EPC STORMWATER REVIEW COMMENTS
IN ORANGE BOXES WITH BLACK TEXT

EAGLE FOREST SUBDIVISION

Construction Drawings

El Paso County, Colorado

G1

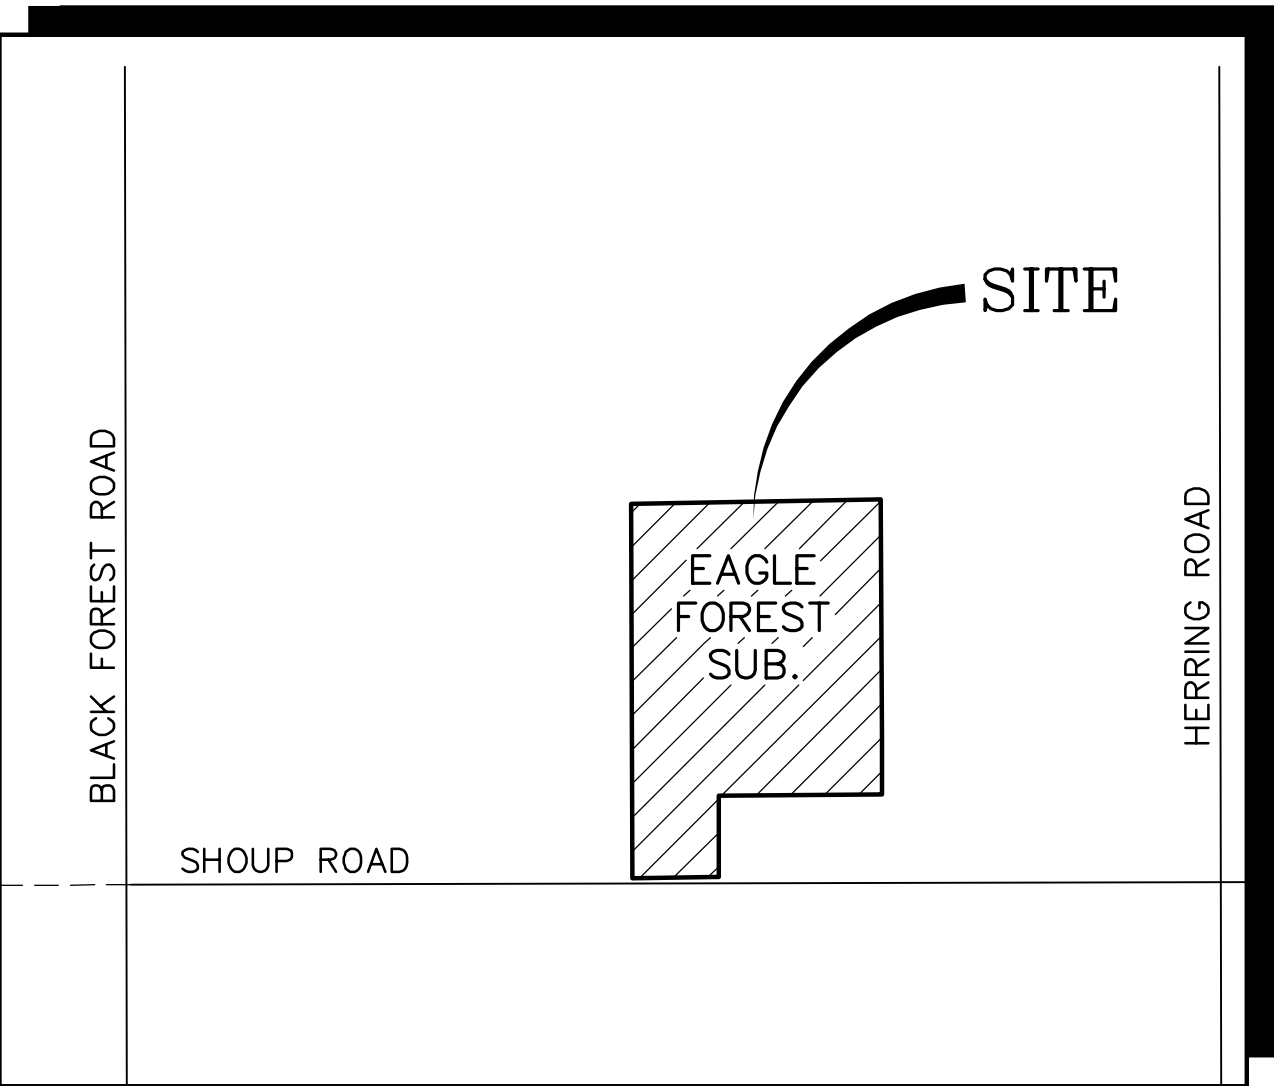
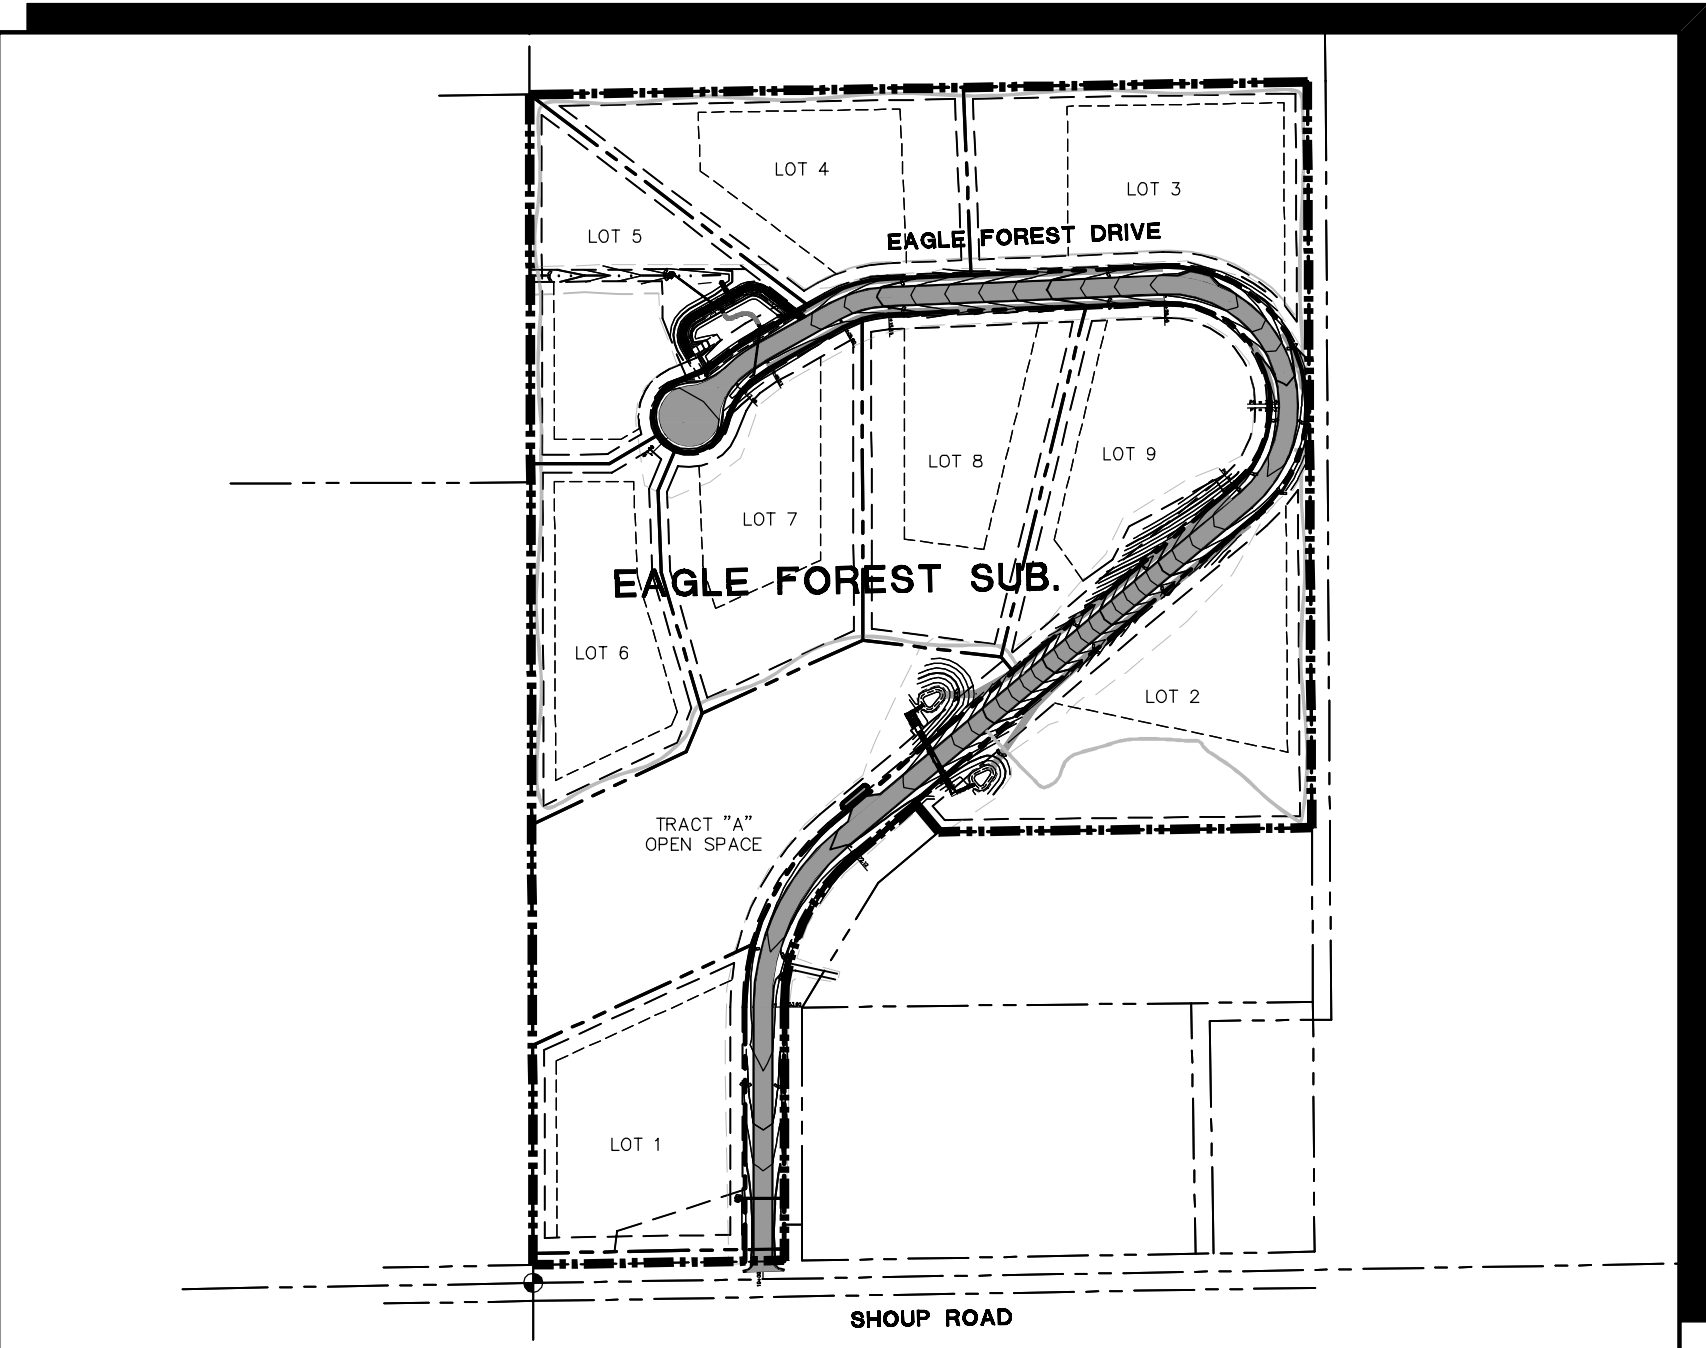
Add text:
PCD Filing No.:
SF-21-31

revise per GEC Checklist Item "ii"

Switch the order of these 2 paragraphs.

HORZ. SCALE:	N/A	DRAWN:	BJJ
VERT. SCALE:	N/A	DESIGNED:	JPS
SURVEYED:	LWA	CHECKED:	JPS
CREATED:	3/17/12	LAST MODIFIED:	6/9/21
PROJECT NO:	010501	MODIFIED BY:	MSP
SHEET:	C2

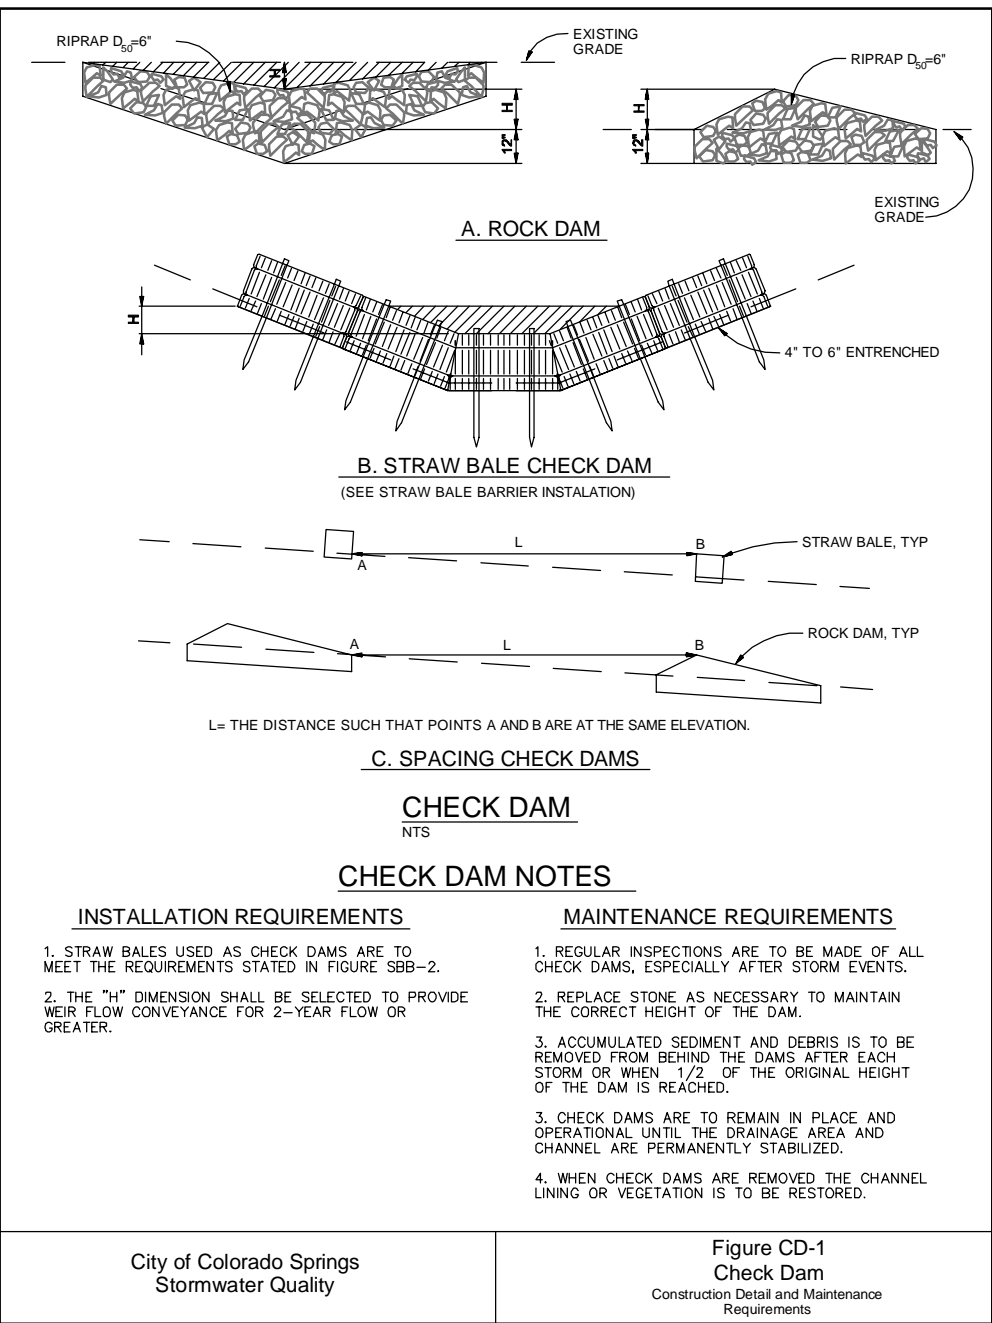
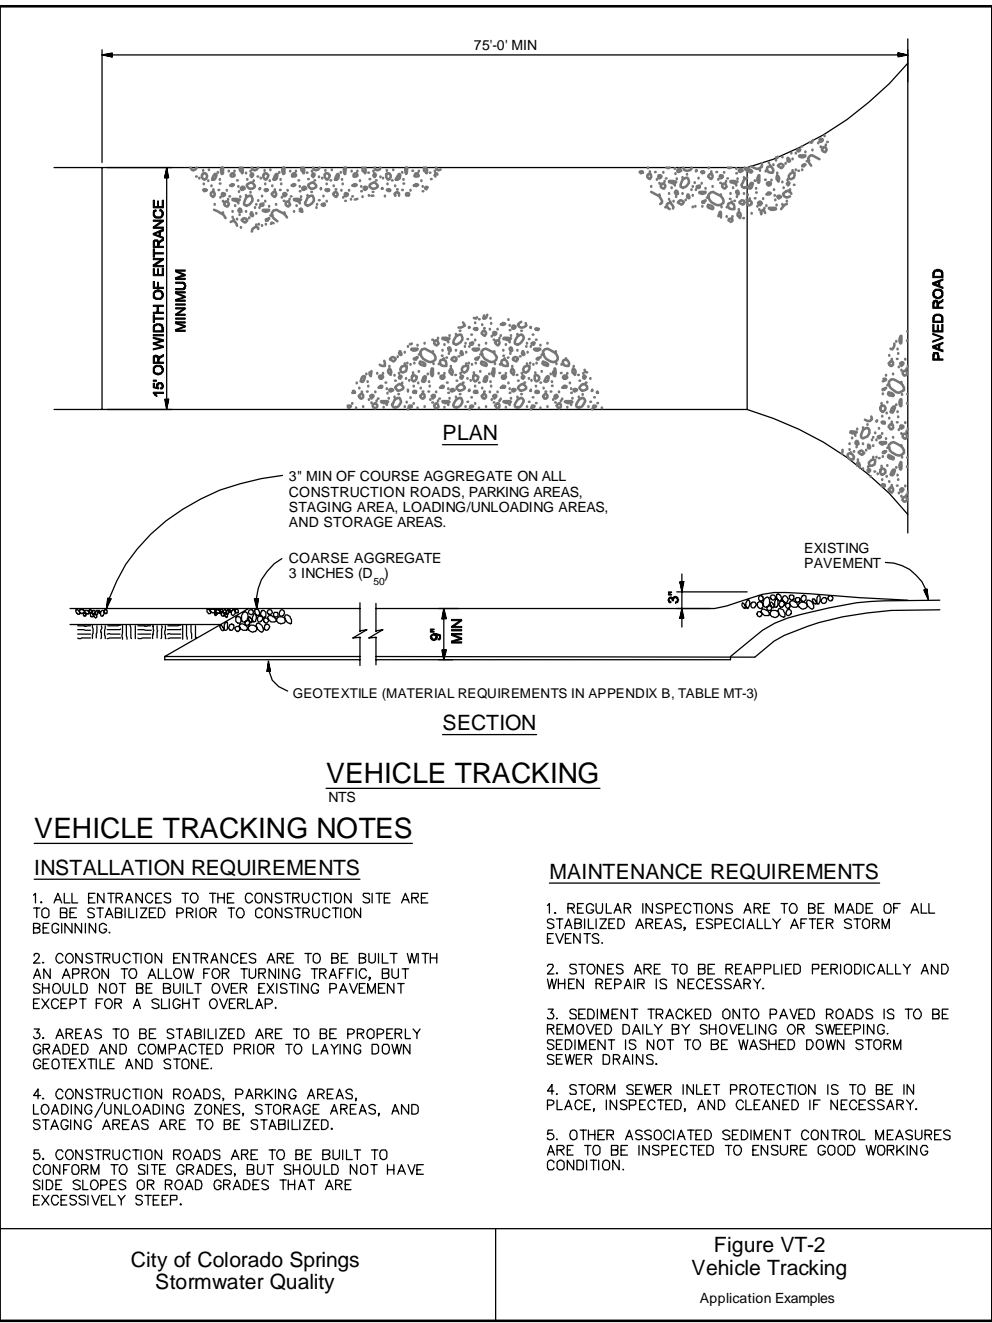
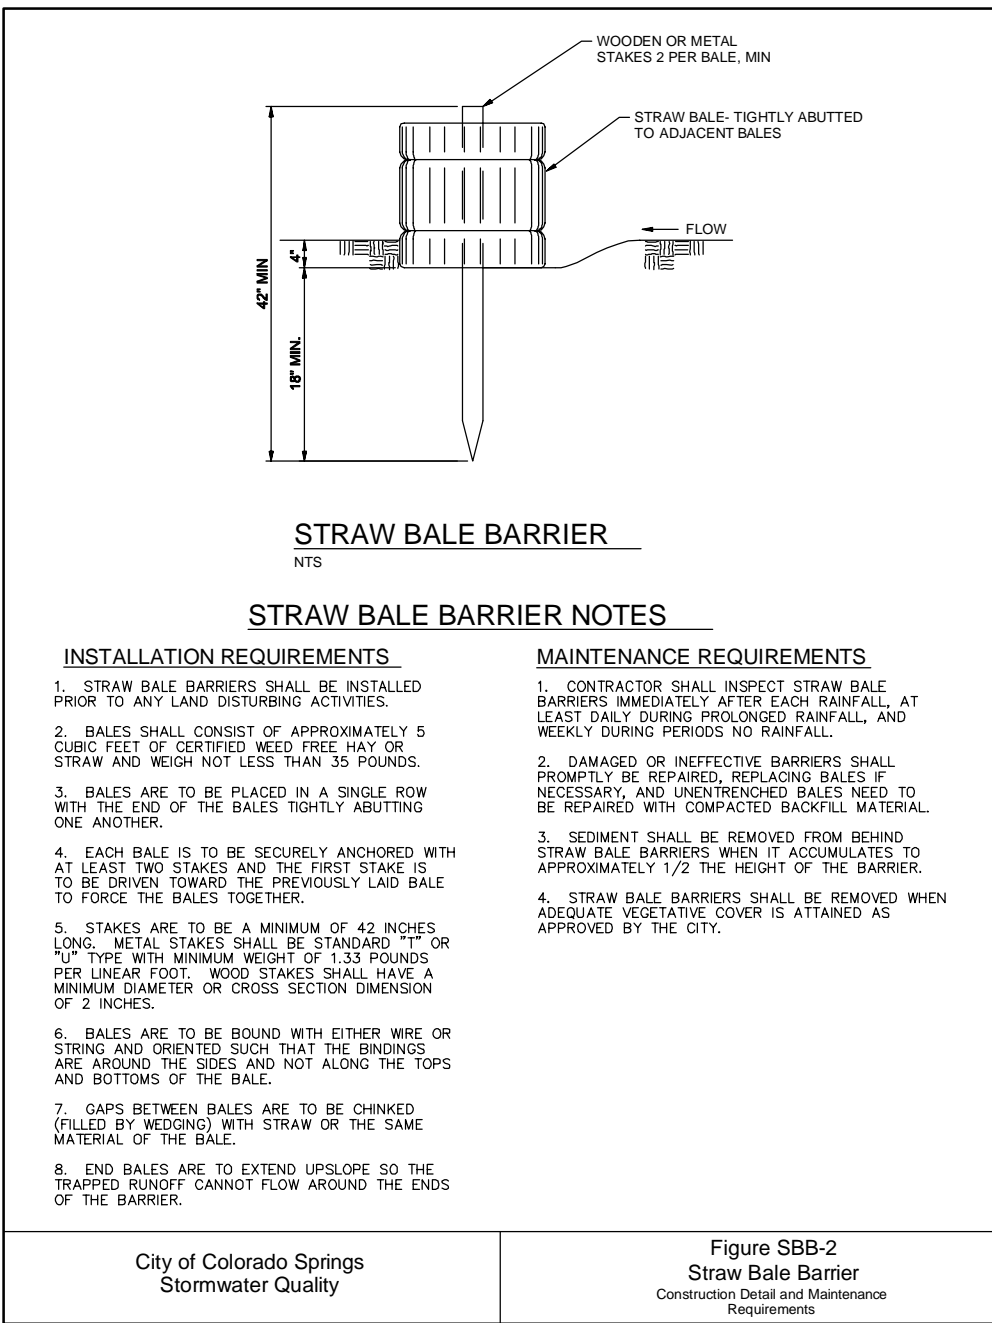
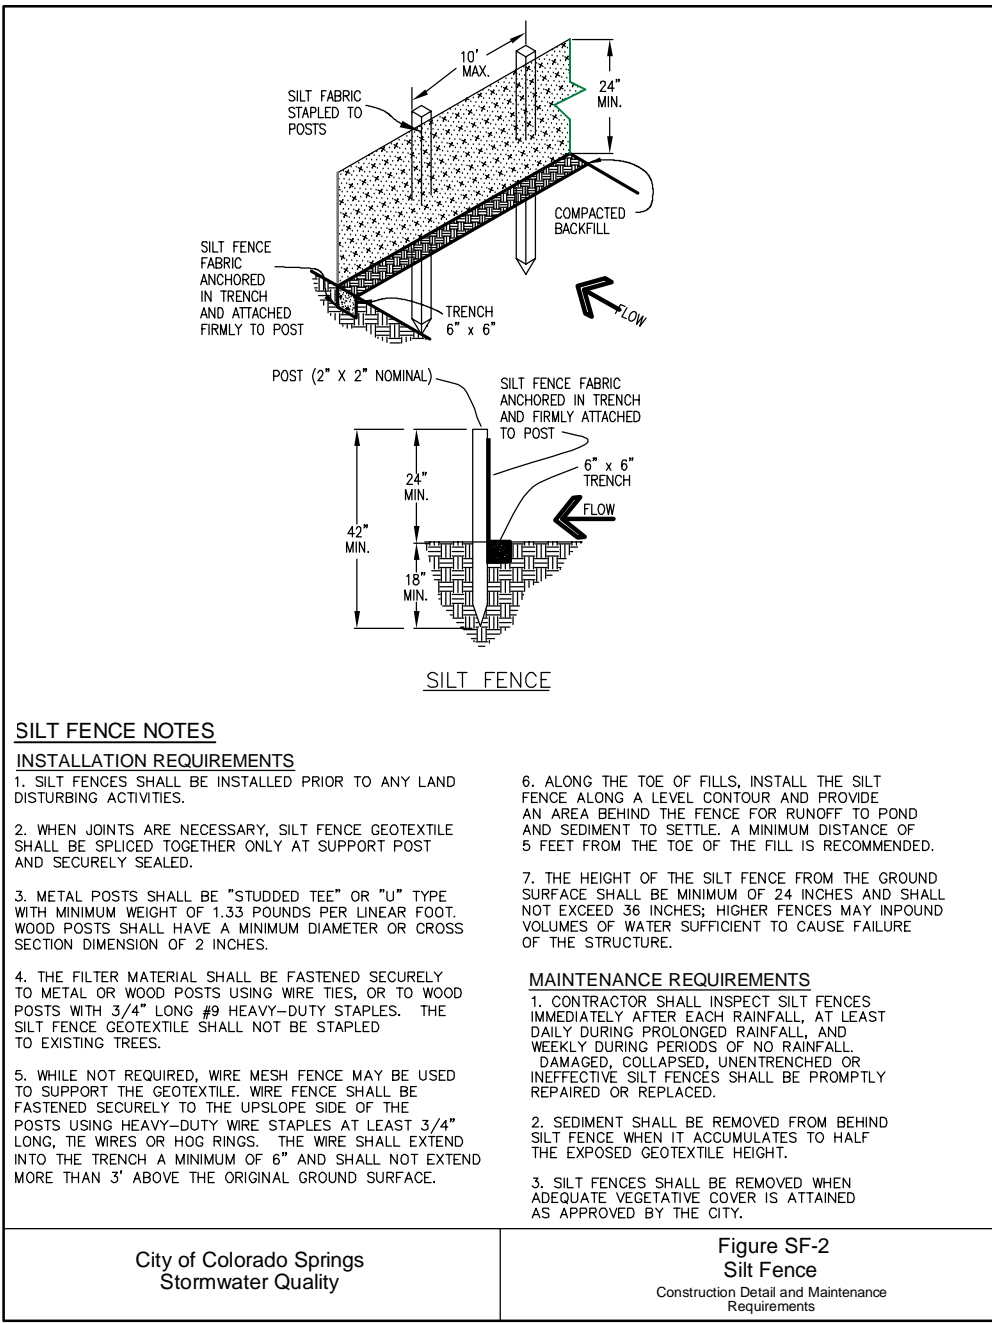
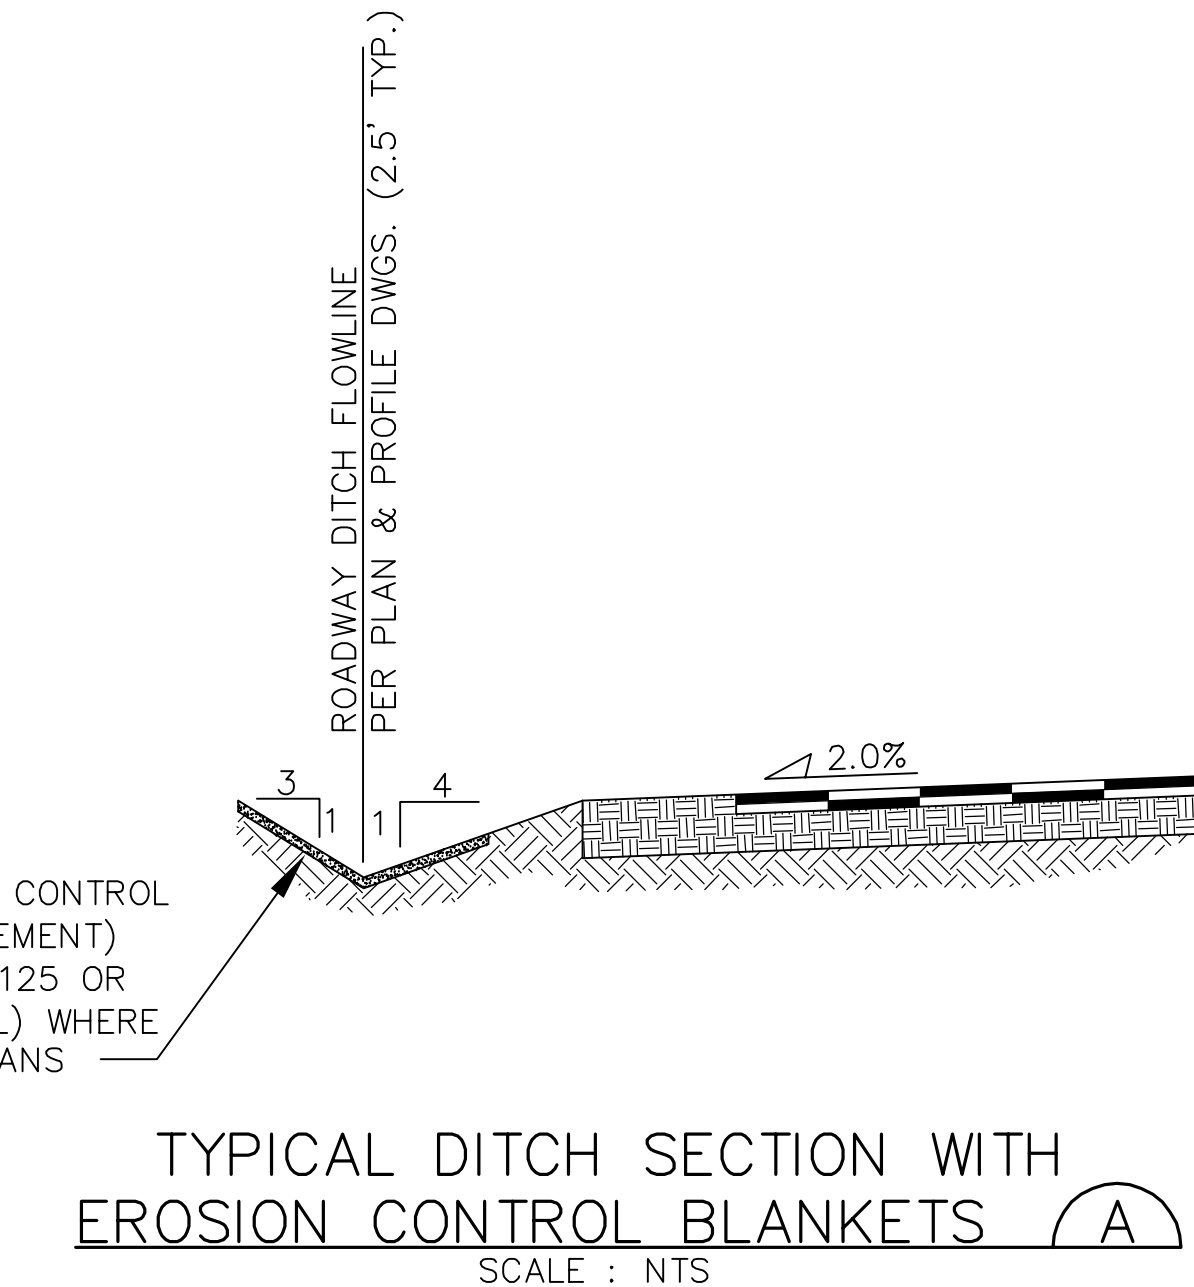
Shown in FAE. Show location on plans and Legend.

Include details for the following BMP's. Examples of acceptable details for each are provided:
